KITTITAS COUNTY

DEPARTMENT OF PUBLIC WORKS

January 9, 2008

RE: Tumbling Ridge PUD

A PORTION OF SECTION 31, TOWNSHIP 20 NORTH, RANGE 15 EAST. W.M. KITTITAS COUNTY

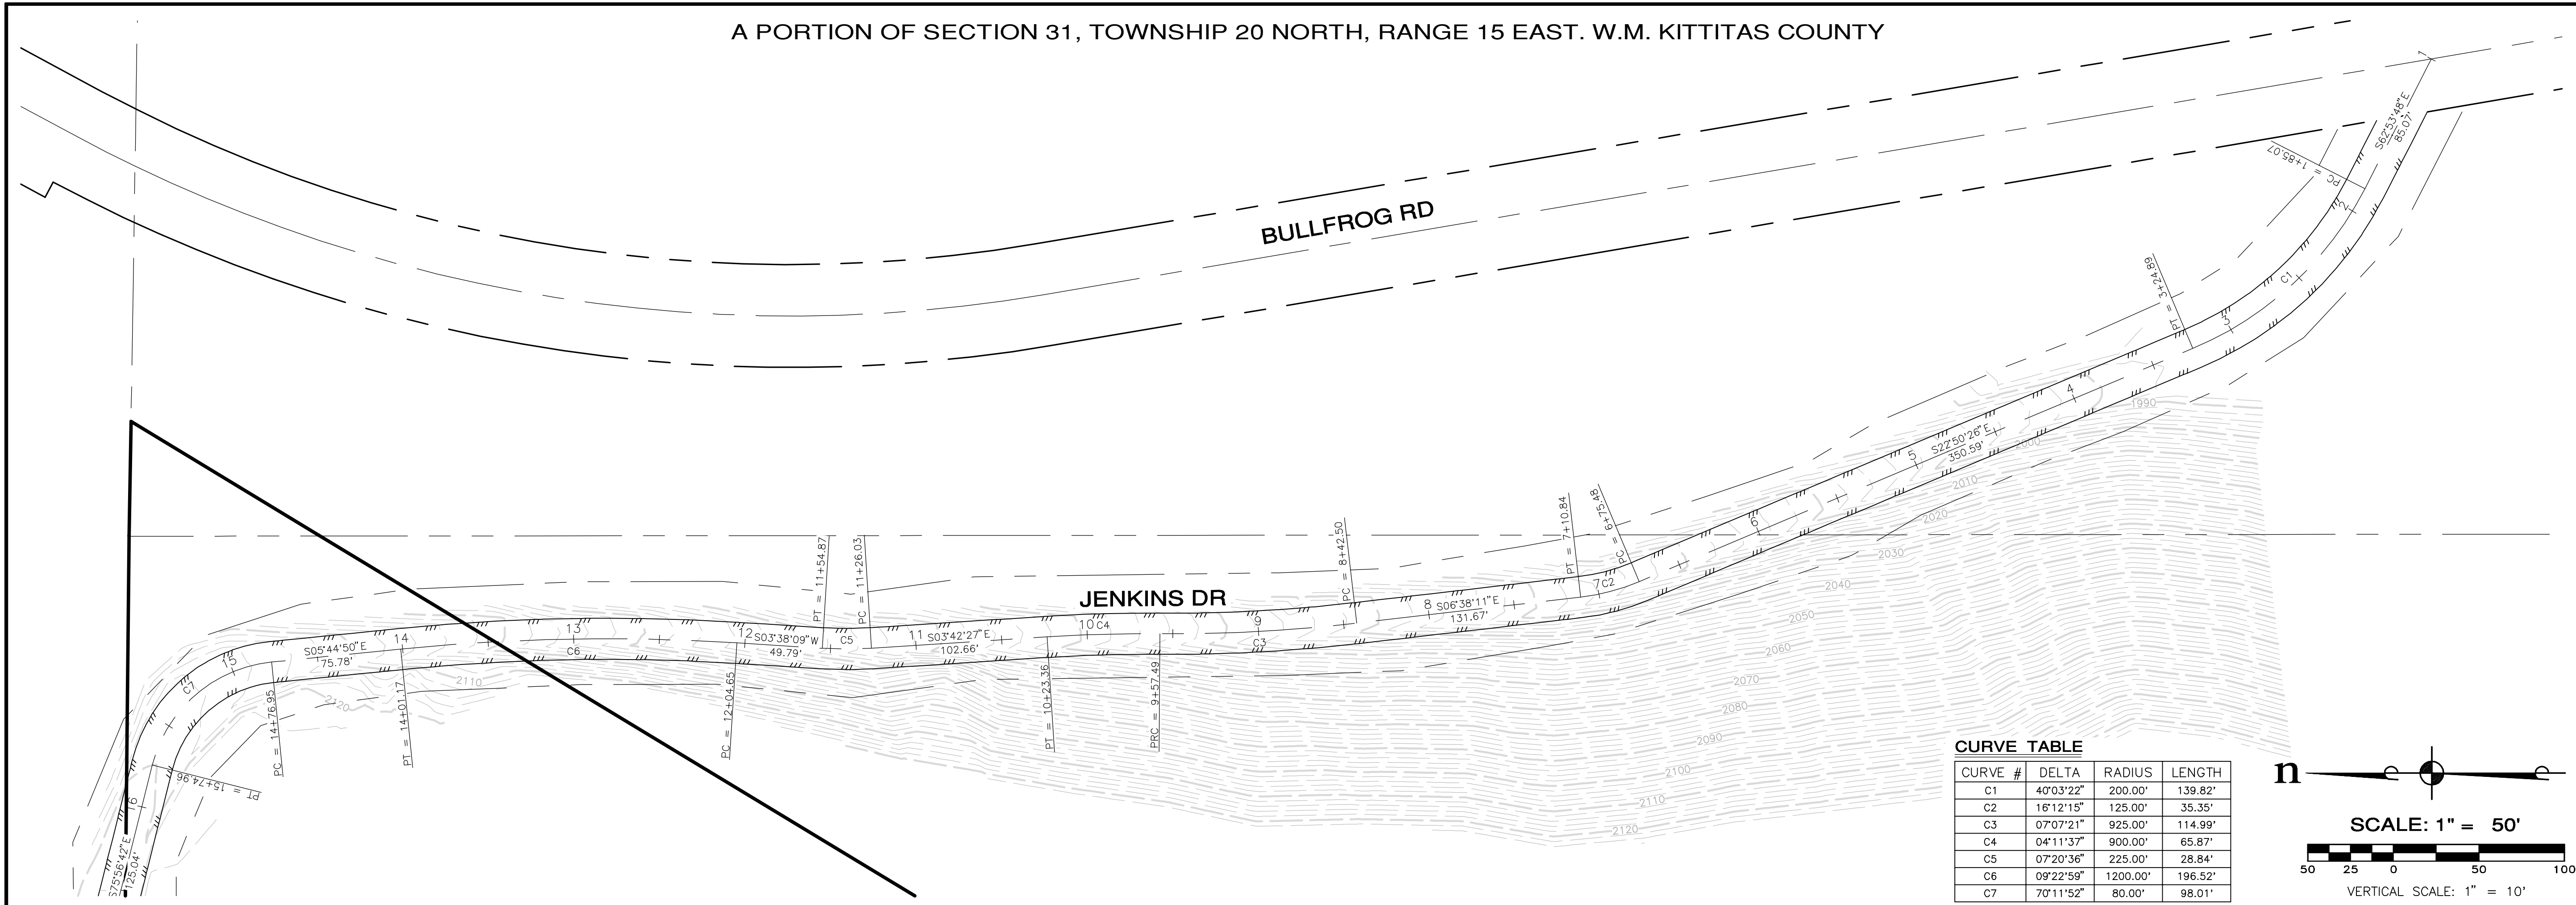
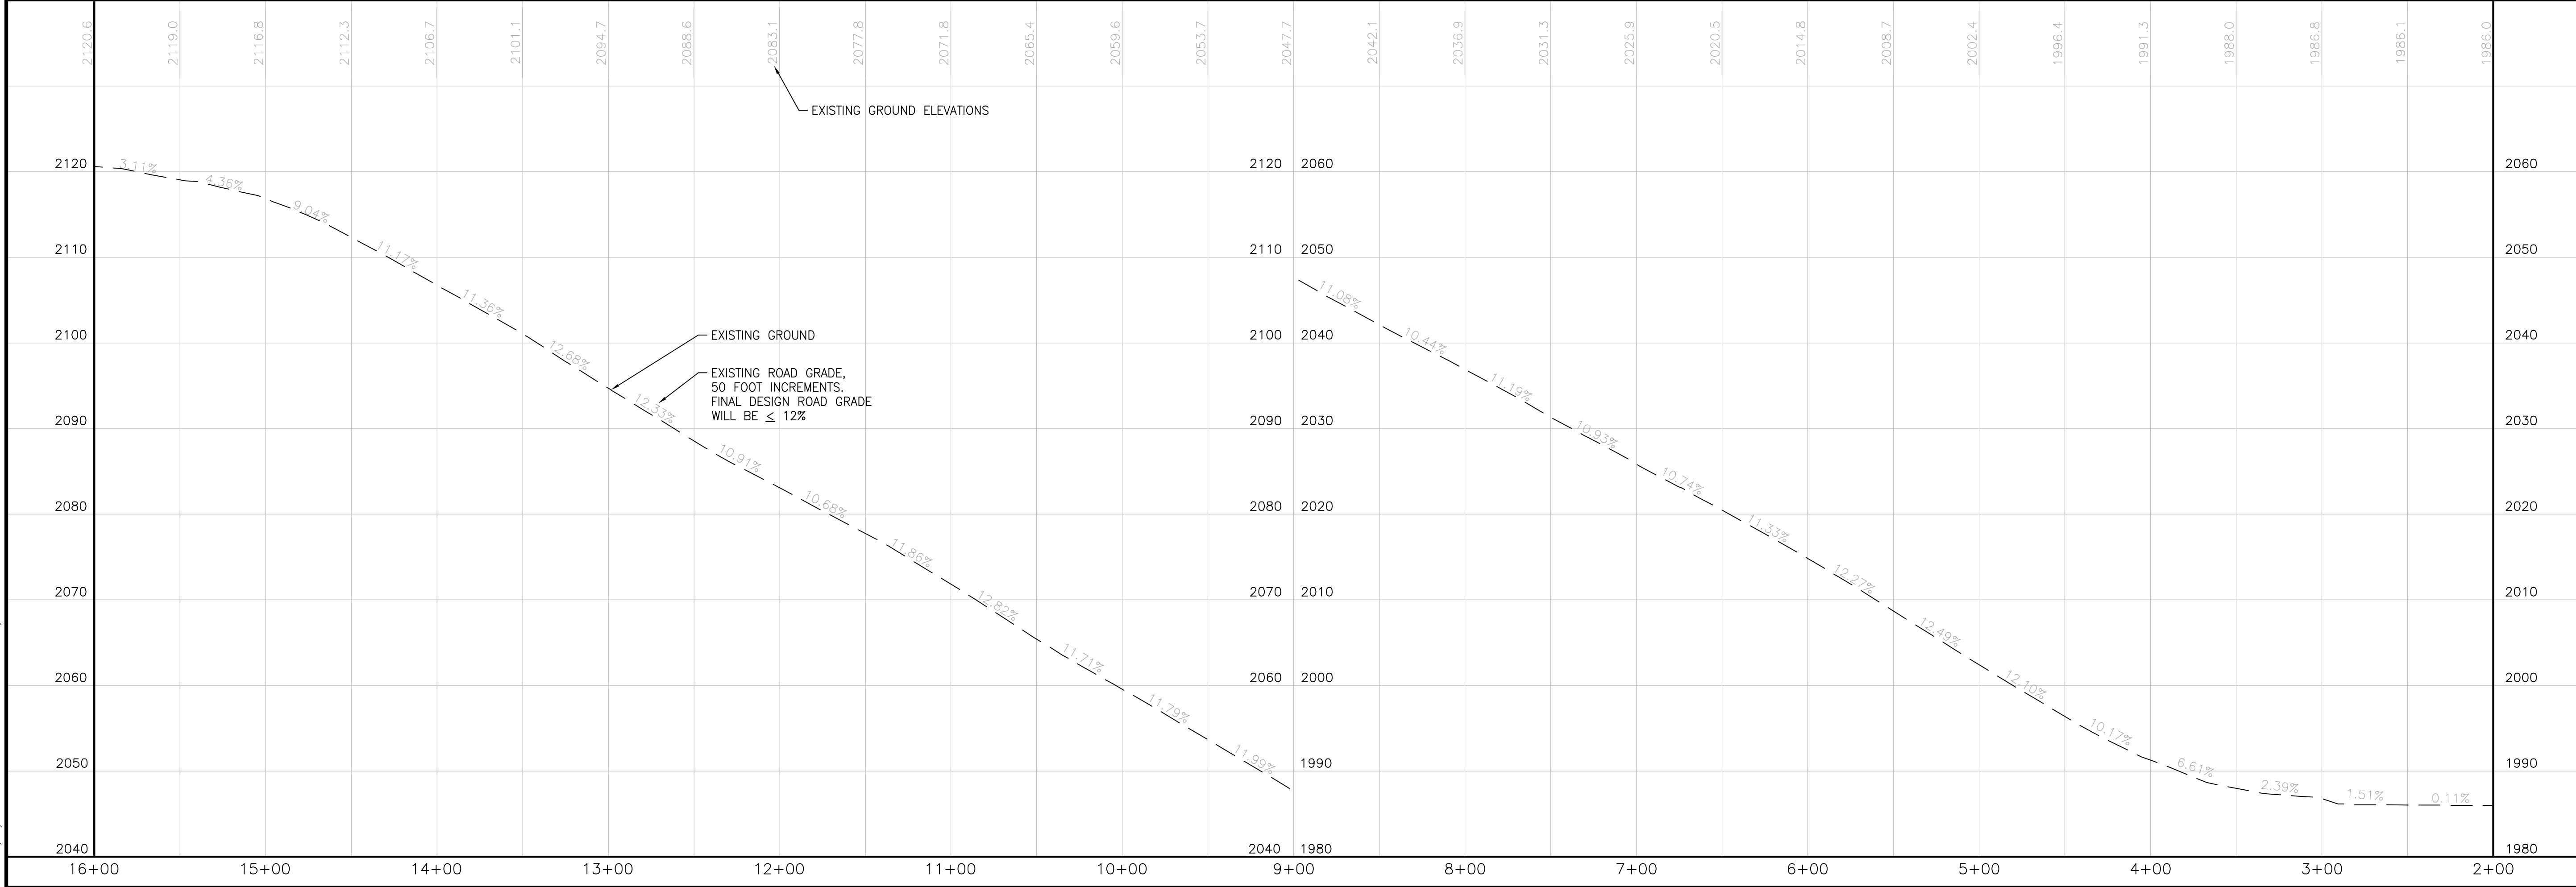
Per Kittitas County Code 16.12.020 (A), the Director of Public Works can require road plans and profiles prior to preliminary approval. Due to the history and known issues of Jenkins Drive, road plans and profiles shall be required for review to ensure that Jenkins Drive can meet the requirement of KCC 12, Kittitas County Road Standards. This information shall be required prior to preliminary approval.

Proposed road plans and profiles shall be prepared by a licensed civil engineer and shall be submitted on standard 22" x 36" sheets for review. The scale shall be 1" = 100' horizontal and 1" = 10' vertical, sheet one.
